MEMORANDUM

DATE: June 12, 2014
TO: Rita T. Harmon, P.E.
PROJECT: Sunset Subdivision
TOPIC: Response to Comments dated June 10, 2014

PAGE TITLE
Lot 30-P1 Grading Plan

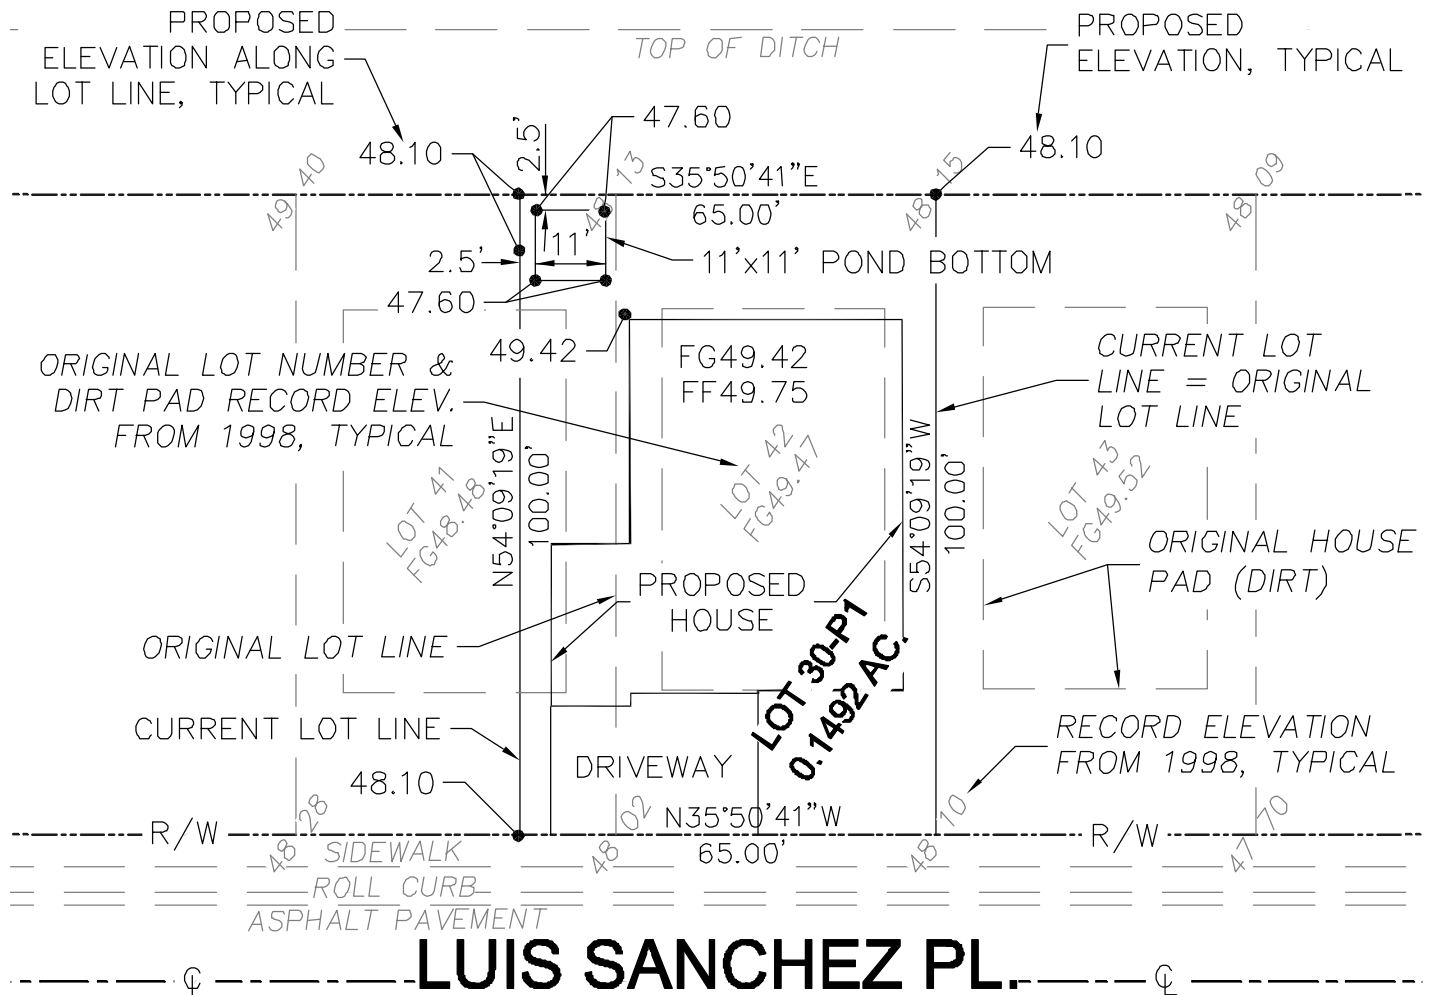
1. The purpose of this submittal is to request approval for only Lot 30-P1, although the table on the first page of the calculations dated May 6, 2014 does compare all 10 lots. For the purpose of this submittal, please consider it for Lot 30-P1 only. Separate submittals will be made for other lots at the time of building permit request for those lots.

2. Based on the overlay of the lots graphically shown on Page A-7, lot 30-P1 is located where 3 lots currently held by my client exactly overlay 4 of the lots originally platted in 1998. So for lot 30-P1, we have computed 2800 sq. ft. would be the allowed impervious area of this lot, based on the amount of impervious area originally allowed for these lots. I believe your comment agrees with this for the three lots that include lot 30-P1.
We wish to create 3300 sq. ft. of impervious area on lot 30-P1 rather than the 2800 sq. ft. originally allowed, which is an additional 500 sq. ft. I discussed how to compensate for this increase with Mr. Curtis Cherne of your office a couple of times in May. He said we need to compensate for increased runoff produced BY a given lot, by creating additional ponding ON that lot. That is why we have created additional ponding volume on Lot 30-P1.

3. In 1998 when we originally designed the ponding for this subdivision, the entire site WAS graded flat, with the exception of the house pads, as proscribed in the report at that time. This flat grading results in a 100-year water surface elevation of 48.42 across the entire Unit 1 area. By digging out some additional depth on lot 30-P1 only, as compensation for the additional runoff produced by that lot, it does not block surface runoff from the rest of the subdivision, and the 100-year water surface elevation will remain at 48.42. I believe this complies with the intent of the referenced drainage report, and is also consistent with the instruction of Mr. Cherne referenced above.

4. Similar to the rationale listed in comment 3, no obstructions to flow between the front and back yards are being proposed. The 100-year water surface elevation will still be 48.42 across the entire lot.
